**Application by H2Teesside Limited for an Order Granting Development Consent for the H2Teesside Project**

**Response to Deadline 2 – Written Representation**

## Sembcorp Written Representation

**FIGURE TITLE**  
Artificial Geology - Hydrogen Distribution Network

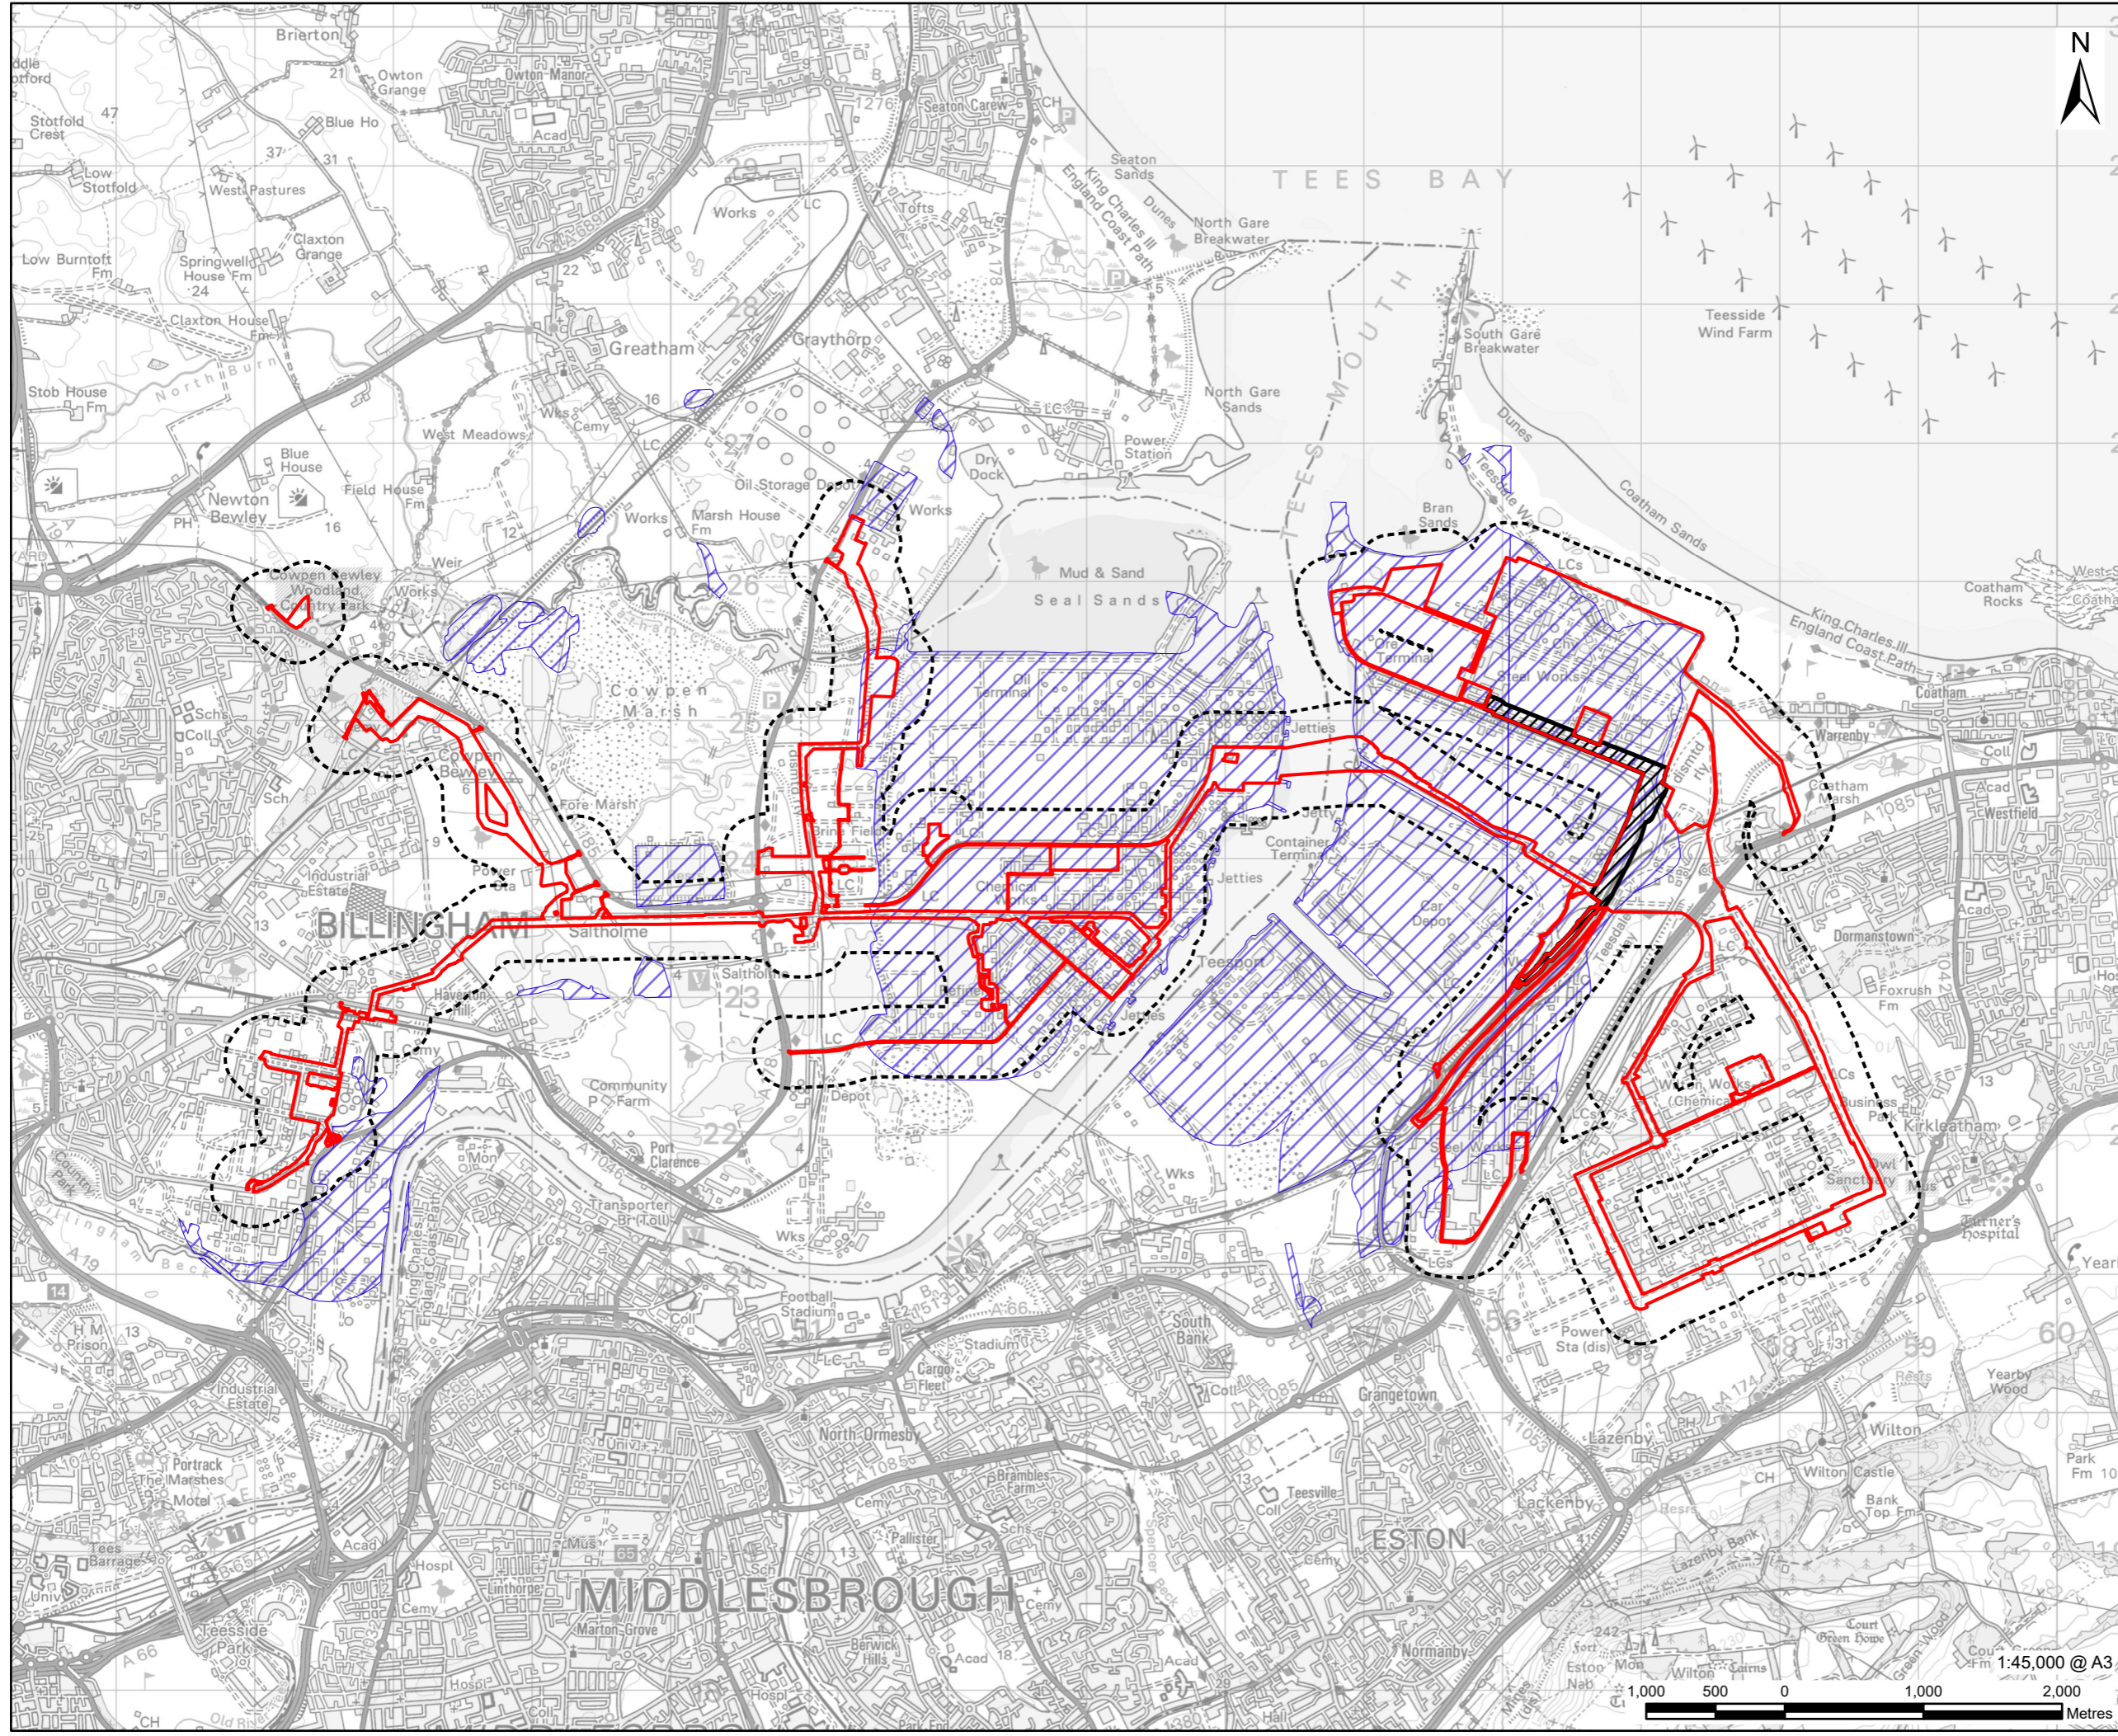
2. **Safety of above ground H2 pipelines**
  - 2.1 Sembcorp has now been able to consider in greater detail the Applicant's Pipeline Statement (document ref 5.5) as well as Chapter 20 of its ES "Major Accidents and Disasters". These documents describe the approach to the Applicant's pipeline connections design as well as its assessment of the potential impacts and effects on Major Accidents and Disasters. Following this consideration, Sembcorp is concerned about the safety of those parts of the Applicant's network comprising above-ground hydrogen pipelines and questions whether, fundamentally, this is a safe approach which is ALARP (as defined in paragraph 20.2.5 of Chapter 20 of the ES).

- 2.2 There are a number of issues regarding the safety of the proposed above ground hydrogen pipelines:
      - 2.2.1 Hydrogen has a high molecular diffusivity and so there is greater propensity for leaks from pipelines and associated infrastructure.

- 2.3 In addition to these inherent risks, the proposed location of the Applicant's hydrogen pipelines introduces further risks. There are a number of existing pipeline assets (many of which themselves convey hazardous substances) and supporting infrastructure/apparatus (steel or concrete supports, pipe bridges, cables etc) above ground in the pipeline corridors. This creates additional risks in the management of major accident hazard pipelines and the potential domino effect of other systems and apparatus in the Sembcorp managed pipeline corridor.

- 2.4 If the hydrogen pipelines were to leak above ground, there would be a greater risk to humans, environmental health and safety, existing systems and apparatus than if they were to be routed below ground. On the basis that the soil coverage of the pipelines inherently reduces risk.

Whilst the Applicant may not be able to eliminate or substitute the hazard in this case, it can certainly seek to further isolate the hazard by burying the pipelines. This would significantly reduce the risks identified above.

- 2.6 Within the Wilton International site, Sembcorp is also concerned that there are further interactions/domino effects risks that come into play with above ground pipelines. The site has tenants that are upper and lower tier COMAH facilities and thus careful consideration is needed before introducing further risks into this complex environment. Furthermore, the site will be subject to further development and Sembcorp is concerned that the presence of above ground hydrogen pipelines may prevent development on parts of the site within the impact zones of the hydrogen pipelines.

- 2.7 In addition to this, the presence of hydrogen pipelines above ground may disproportionately use up capacity in the pipeline corridor, since greater buffers may be needed above ground to achieve appropriate separation. This in turn may impact on the ability of future projects to utilise the corridor and is not an efficient use of the limited available space remaining.

- 2.8 Route selection for pipelines in TD/1 should, as far as possible, avoid running closely parallel to high density traffic routes, railways, overhead electricity transmission lines, major pipelines or other buried plant. External interference of above ground pipelines is considered as a specific threat to pipeline integrity as indicated in TD/1 with gas pipelines being buried this significantly reduces this risk. The Applicant advises in the ES Table 20-5 the standards to be utilised will be "IGEM/TD/1 Ed.6, including Supplement 2. ASME B31.12," TD/1 is specifically related to buried pipelines and minimising above ground infrastructure on gas pipelines. Hydrogen is inherently less safe than natural gas, from a fire and explosion standpoint as detailed.
